**KIRKLEES METROPOLITAN COUNCIL
INVESTMENT & REGENERATION SERVICE**

DELEGATED DECISION TO DETERMINE PLANNING APPLICATIONS

Reference No:	2024/62/91403/W
Site Address:	116, Underbank Old Road, Holmfirth, HD9 1AS
Description:	Installation of replacement UPVC patio door (within a Conservation Area)
Recommending Officer:	Joanna Rednall

DECISION – CONDITIONAL FULL PERMISSION

Drg No:
PE201

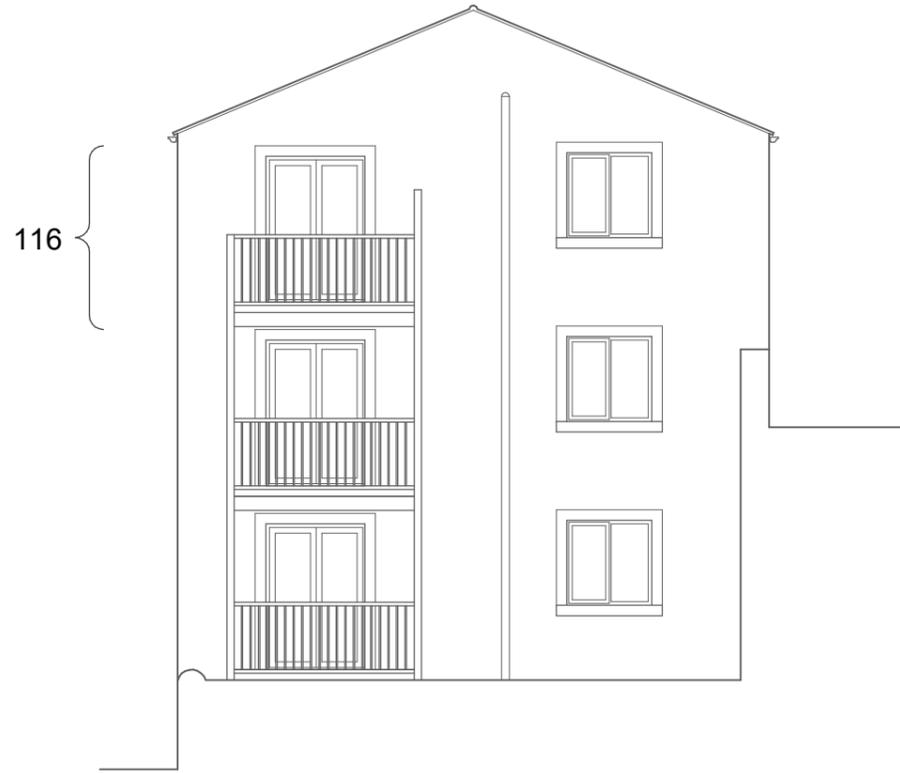
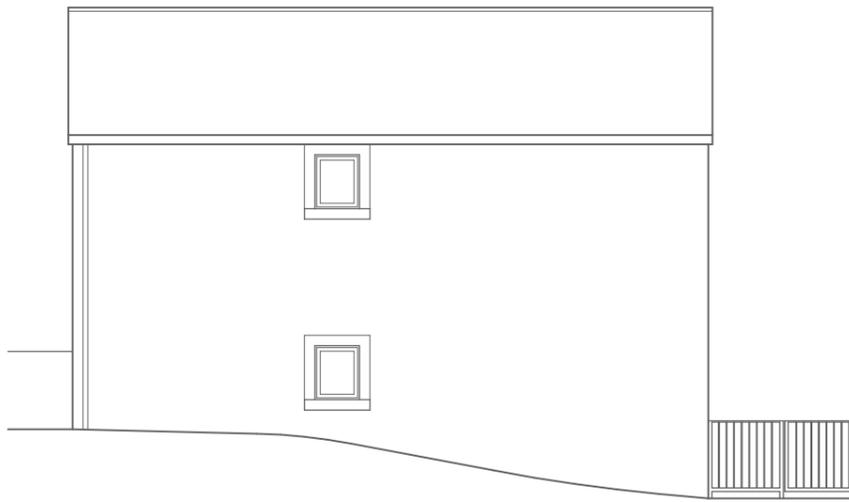
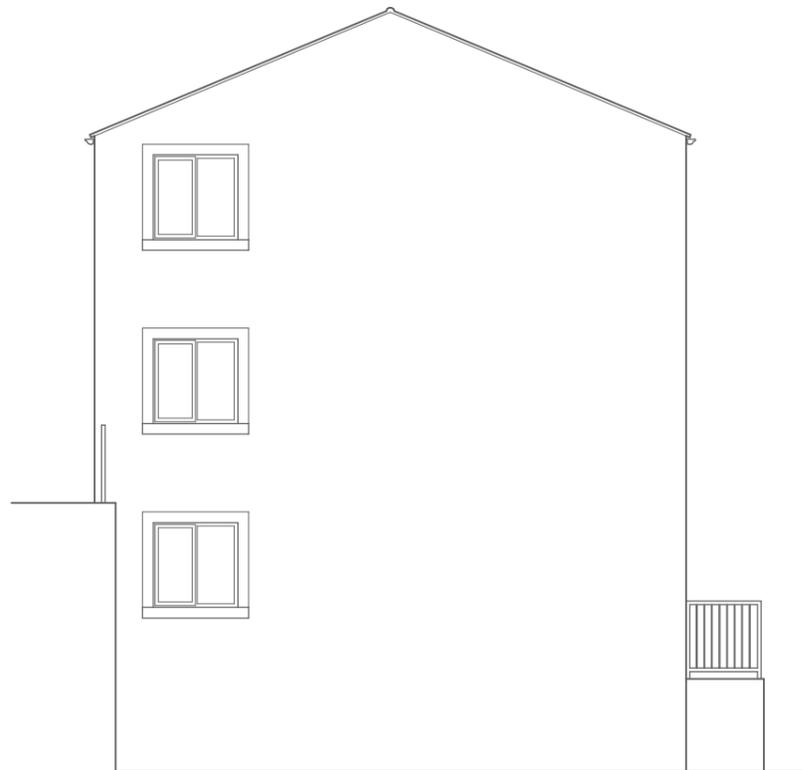
Following discussions with KC Conservation & Design, it was suggested to the applicant that the doors should be constructed from either timber or aluminium to be in keeping with the design and character of the property and wider street scene. The applicant agreed to amending the proposed materials from UPVC to aluminium.

KC Conservation and Design (informal) – no objection but would advised identical timber frame doors or aluminium doors would be more appropriate instead of UPVC.

1. Notwithstanding the submitted details, the replacement doors hereby approved shall be constructed from aluminium and be a white colour finish. The development shall be thereafter retained in accordance with the materials and colour finish approved by this condition.
Reason: In the interests of visual amenity to accord with Policies LP1, LP2, LP24 & LP35 of the Kirklees Local Plan, Policy 1 & 2 of the HNVDP, and policies contained within Chapter 12 & 16 of the National Planning Policy Framework
